Engineers Comments Regarding Surface Water Drainage

APPLICATION NO: Y/36/20/DOC

Site Address: Rookery Cottage Hoe Lane Flansham PO22 8NT

Description of Works: Approval of details reserved by condition imposed under ref Y/72/19/HH relating to Condition No 3 - surface water drainage

Surface Water Drainage Strategy

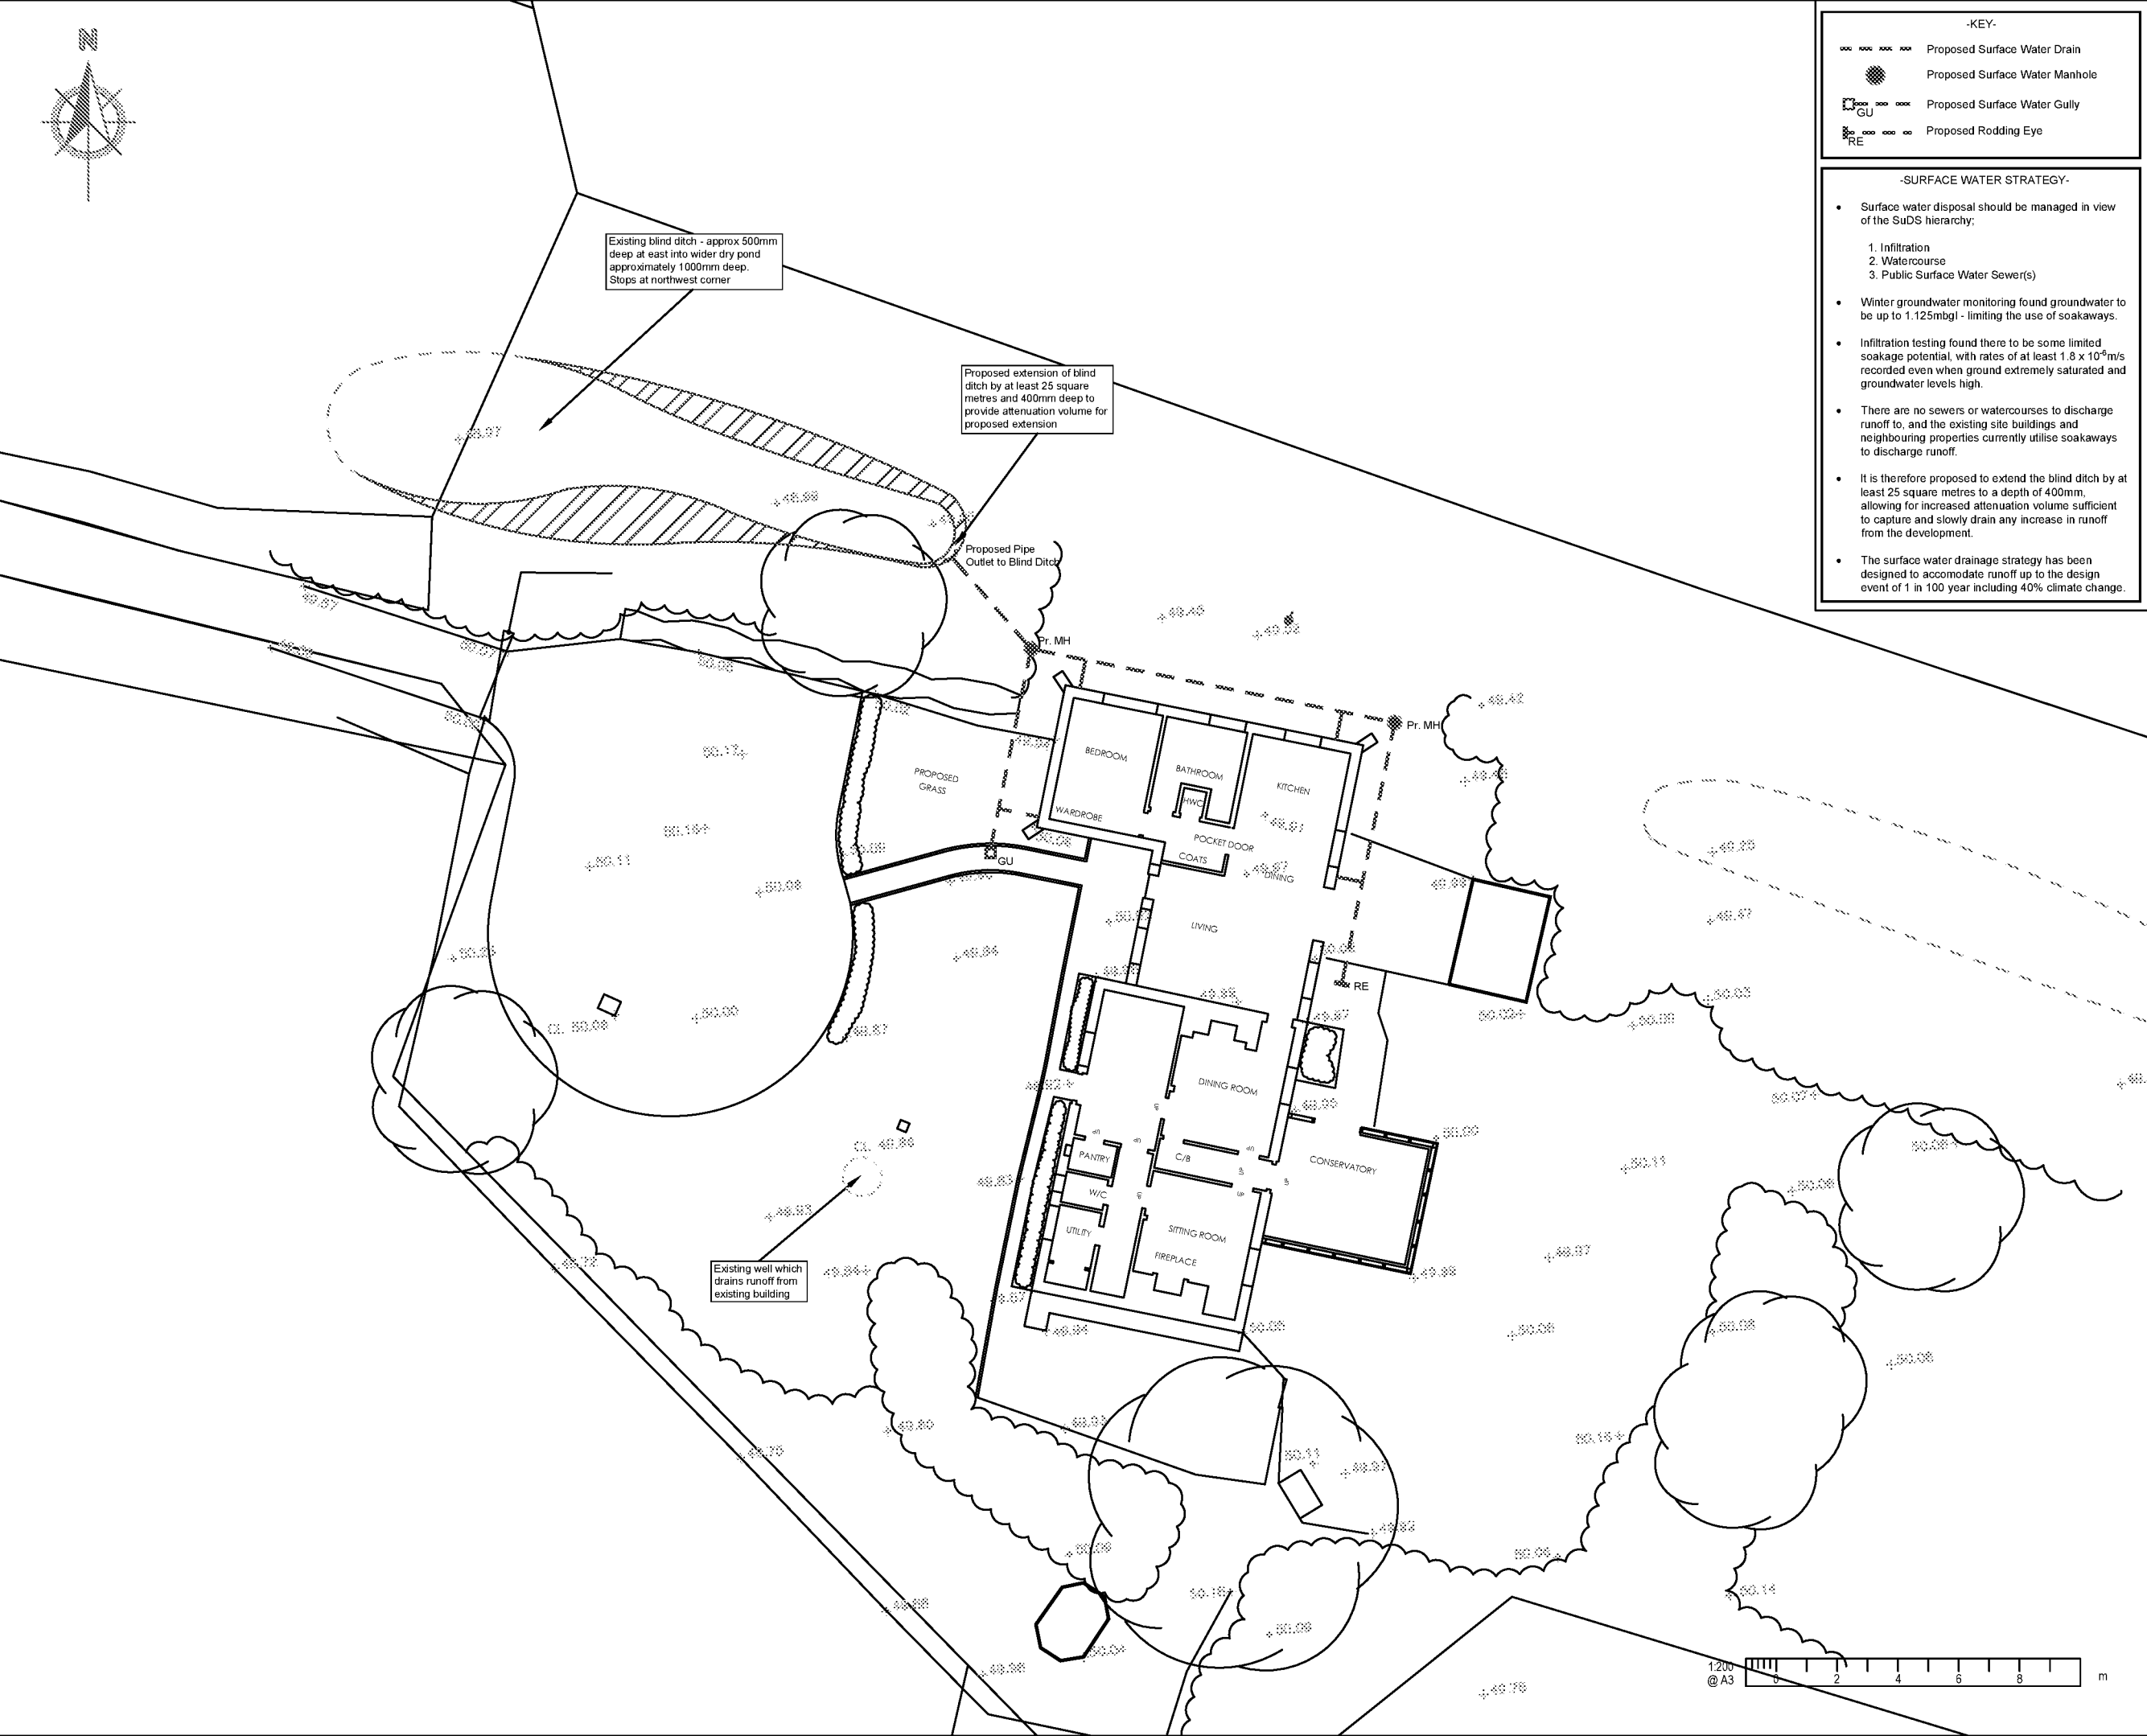
1. Apply for and provide proof of Land Drainage Consent.
2. Label surface water pipes with, diameters, pipe materials, falls and invert levels.
3. Label proposed manhole with cover level, invert level, and cover type.

4. Clearly indicate the location of the flow control structure and label this with outflow rate, invert level and design head.
5. Include construction detail drawings for:

- a. Pipe bed and surround
 - b. Outlet/headwall to the blind ditch
 - c. Control structures/manhole
 - d. Rodding eye
 - e. Gully
6. At least two sections, (cross and longitudinal) of the proposed extension of the blind ditch, these should clearly show the change in capacity. It is likely that two cross sections will be required to do this, one each for the wider and narrower sections of the ditch. These sections should be labelled with invert level, top of bank level, width at the base, and width at the top, side slopes should be a minimum of 1 in 3.
